Arun District Council
Arun Civic Centre
Maltravers Road
Littlehampton
West Sussex BN17 5LF
Planning & Building Control General Enquiries
Tel: (01903) 737756 Fax: (01903) 730442
Dx: 57406 Littlehampton
Minicom: 01903 732765
e-mail: planning@arun.gov.uk
website: www.arun.gov.uk/planning

Application No: EP/25/21/HH
Site Address: Netherby 59A Sea Lane East Preston BN16 1ND
Description of works: Erection of front and rear extensions, garage conversion and revised internal layout.

Thank you for your internet representation made on 29th April 2021 which has been recorded as an objection with the comments as follows:

DRAWING TITLE:
Proposed elevations & floor plans

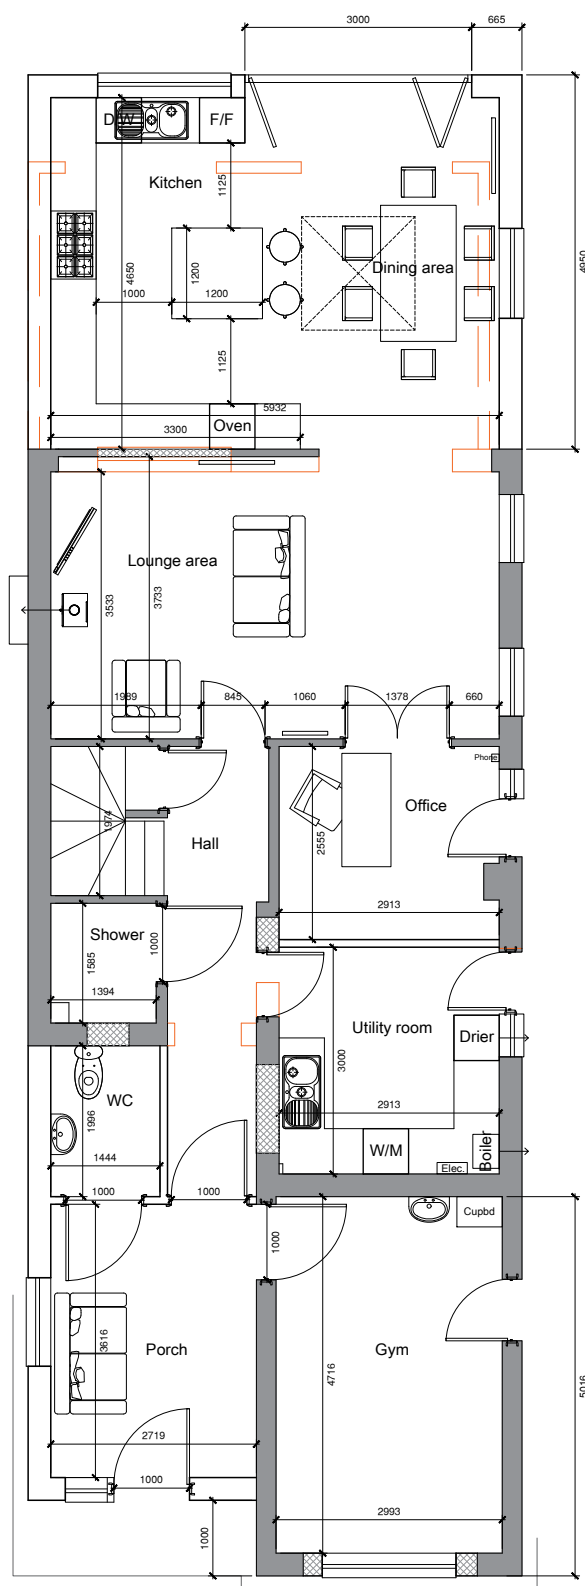
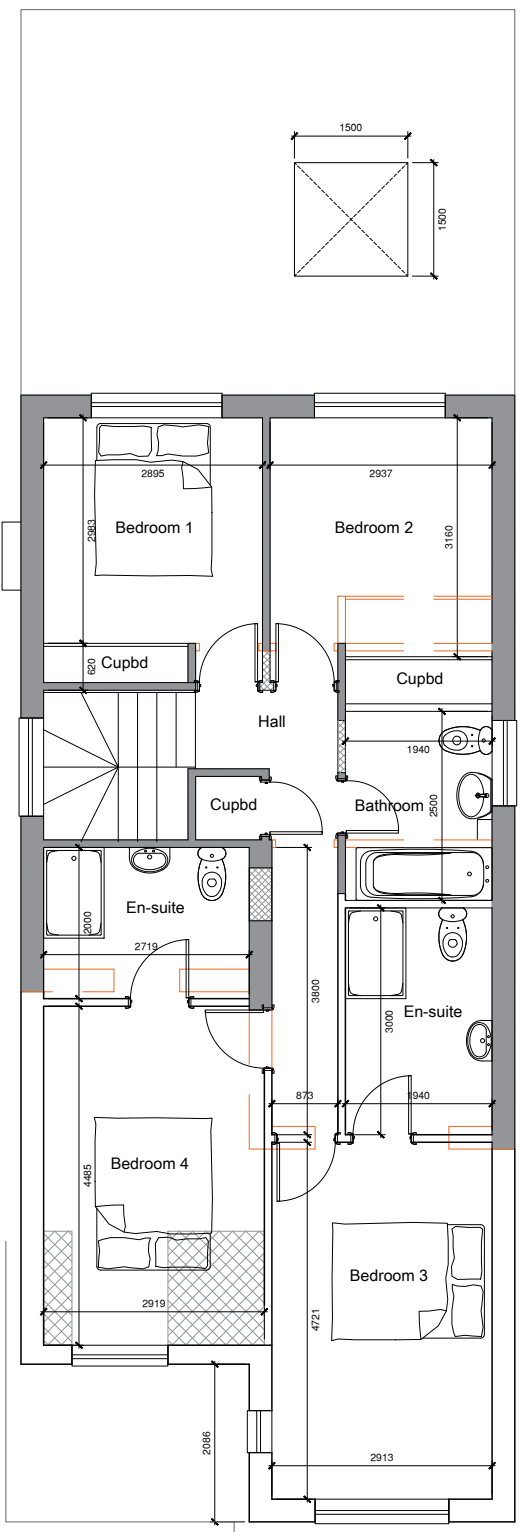
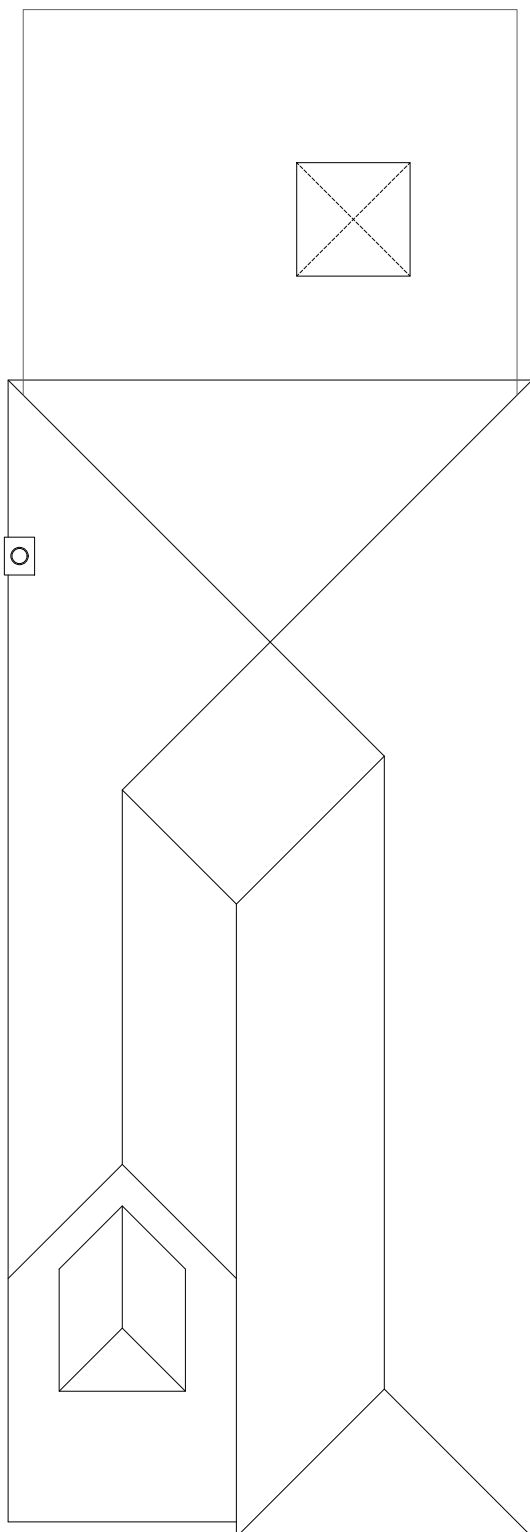
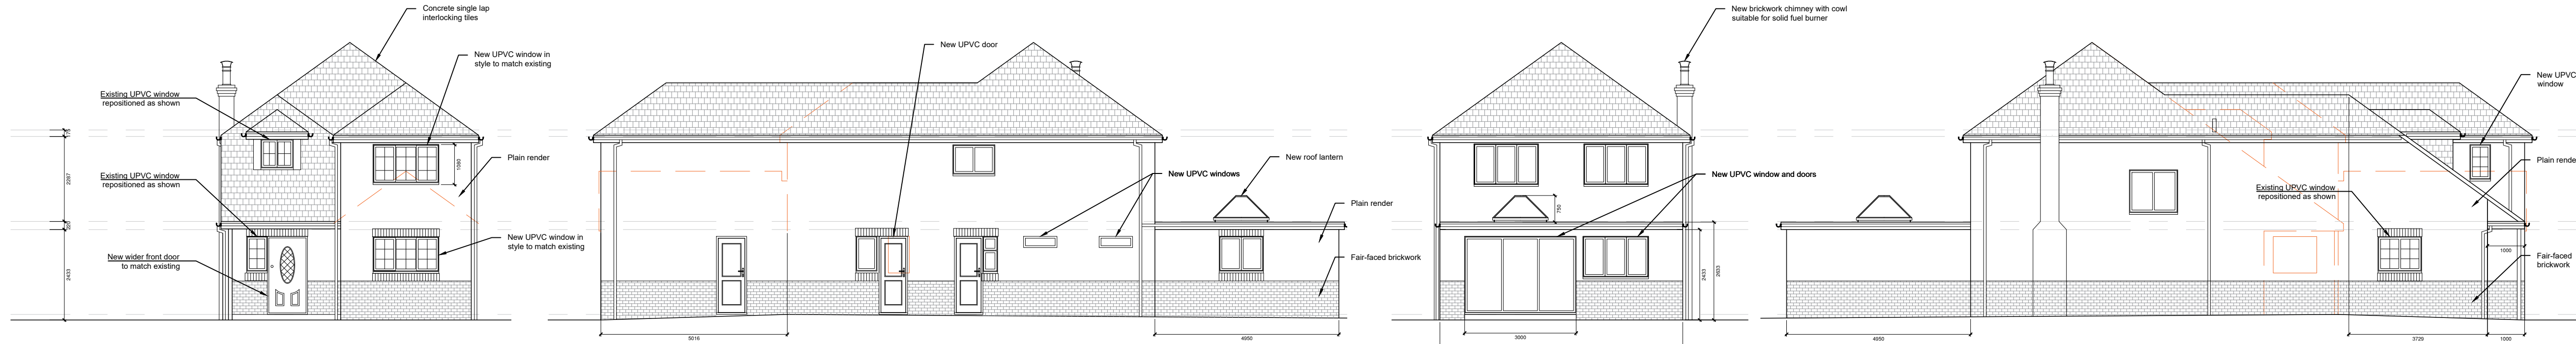
- 1) The rear single storey extension is considered acceptable.
- 2) The proposed front extension however by reason of its size and proximity to site boundaries is thought an overdevelopment of this plot and detrimental to the neighbourhood and to us as neighbours.

- 3) The front extension will take light away from our building, particularly our front room, our lounge.
- 4) The proposed ground floor north facing porch window interferes with our privacy, is unnecessary and should be omitted. If permission is given it should be for obscure glazing and a fixed sash.

- 5) The front first floor extension, over the existing garage, north facing window interferes with our privacy, is unnecessary and should be omitted. If permission is given it should be for obscure glazing and a fixed sash.

- 6) The loss of a parking space and a garage is significant in this area particularly having regard to the applicant's business use of these premises. We feel a parking plan should be provided in order to demonstrate there is sufficient parking for the property. It was a 3 bedroom property with 2 or 3 parking spaces and a garage and now they are proposing a minimum 4 bedroom property with 1 or 2 parking spaces and no garage.
